Ref 19. 1104 Land off Hawthorne Pl.

Applicant Persimmon Homes.

THE HOLYWELL HOUSE TYPE

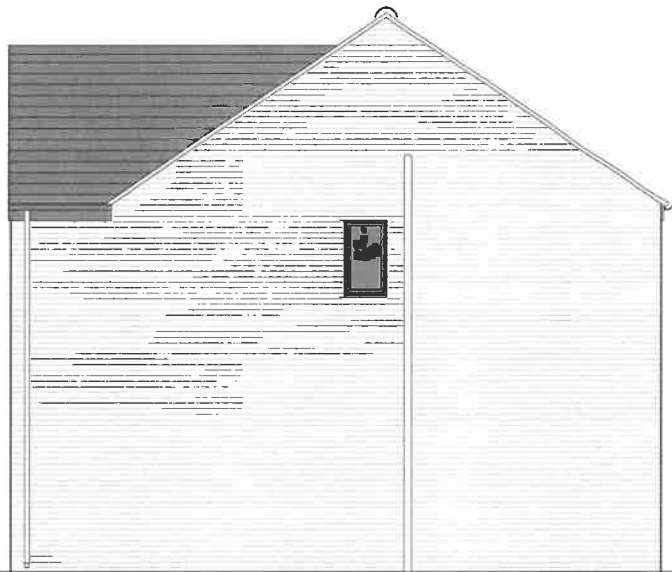
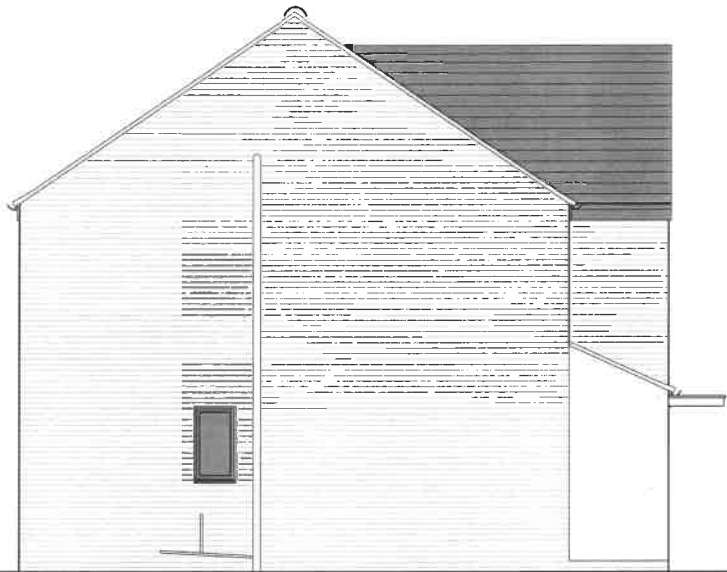
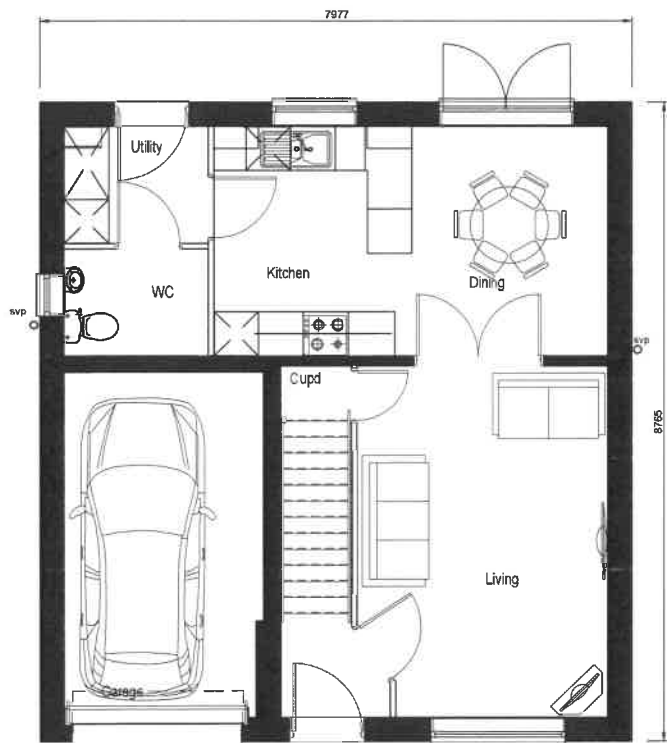
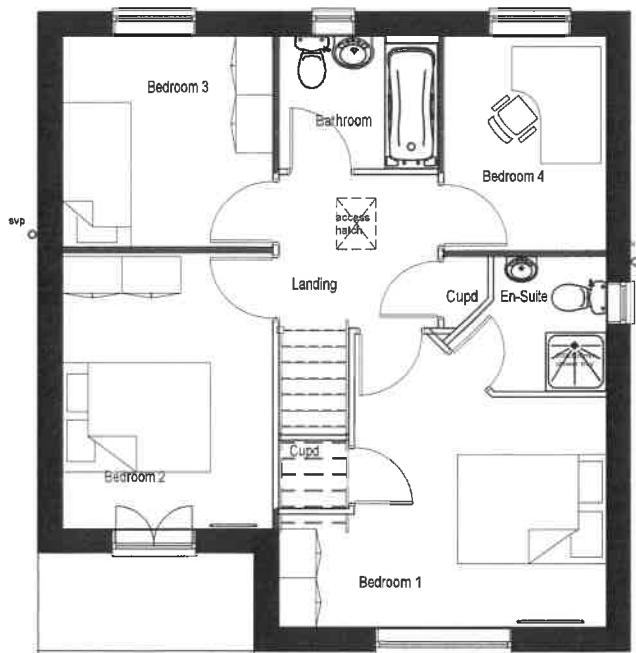
1. The double garage on plot one is too close to our property and will reduce incident light to our lounge and conservatory and feel extremely oppressive ( see enclosed plan and photo). Substantially increasing the Buffer Zone width would help to alleviate this. We have noticed that Buffer Zones on other local developments such as Half Penny Meadows (off Pendle Road) are substantially more generous.

2. We notice that four other Holywell ( HOL) house types have SINGLE garages. So bearing in mind the points made above, Plot One should have a single garage thus moving it away from our property.
